CUMBERLAND
CITY COUNCIL

Our Ref: OA2021/0005
DPIE Ref: SSD-10399

Subject: Request for Comments - State Significant Development (SSD)
Application No: SSD-10399
Property: 44 Clunies Ross Street & Great Western Highway, PROSPECT NSW 2145
615A Great Western Highway & Boral House – Clunies Ross Street,
PEMWULWUY NSW 2145
Proposal: Proposed warehouse and logistics estate at Clunies Ross Street,
Pemulwuy

02 SECTION E-E
SCALE 1:100

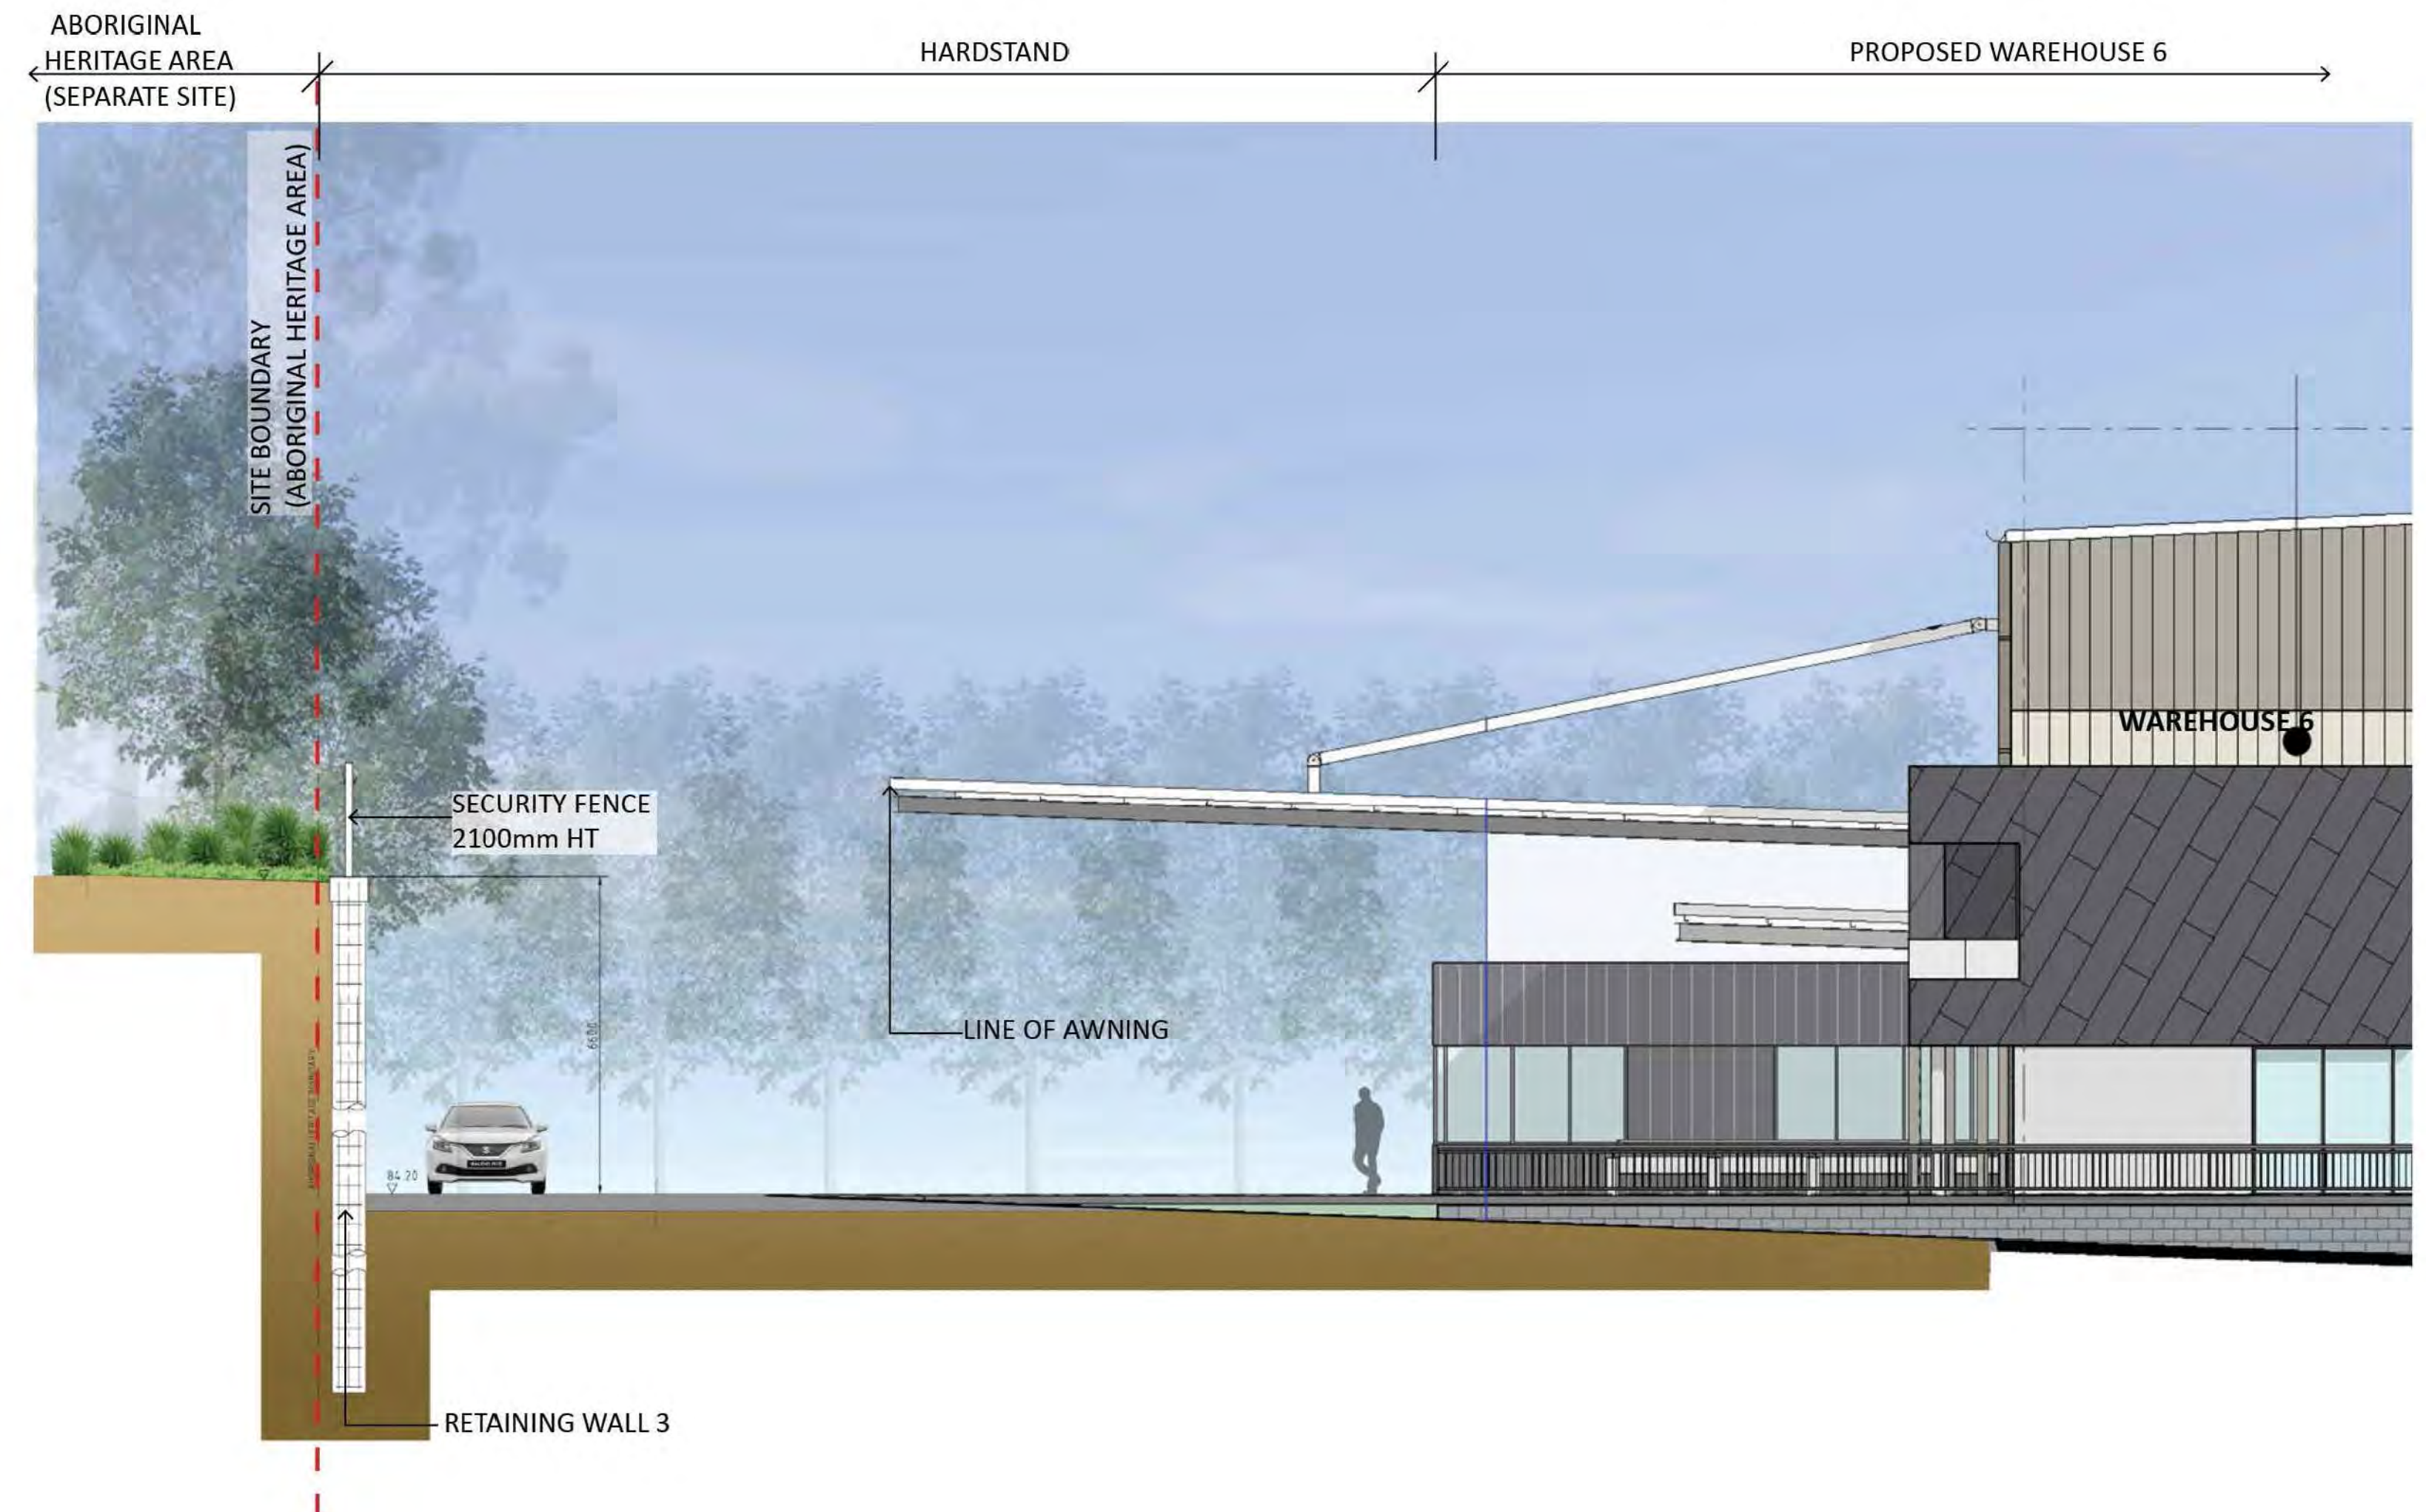
13. Despite of the justification provided in the Statement of Heritage Impact (SoHI), the proposed mature screen planting separating Warehouse 3, 4 and 5 from the view from Prospect Hill is considered to be inadequate as it consists only 1 row of trees along the edge of the heritage reserve and the parking area. The trees proposed will not provide the canopy density to screen such large buildings. Further to that, no plan of the development is included in the SoHI for cross referencing, to show proposed buildings, civil works and, importantly the landscape design and screen planting. Any conditions of consent should mandate recessive tones as well as trees that, at maturity, will screen the development.
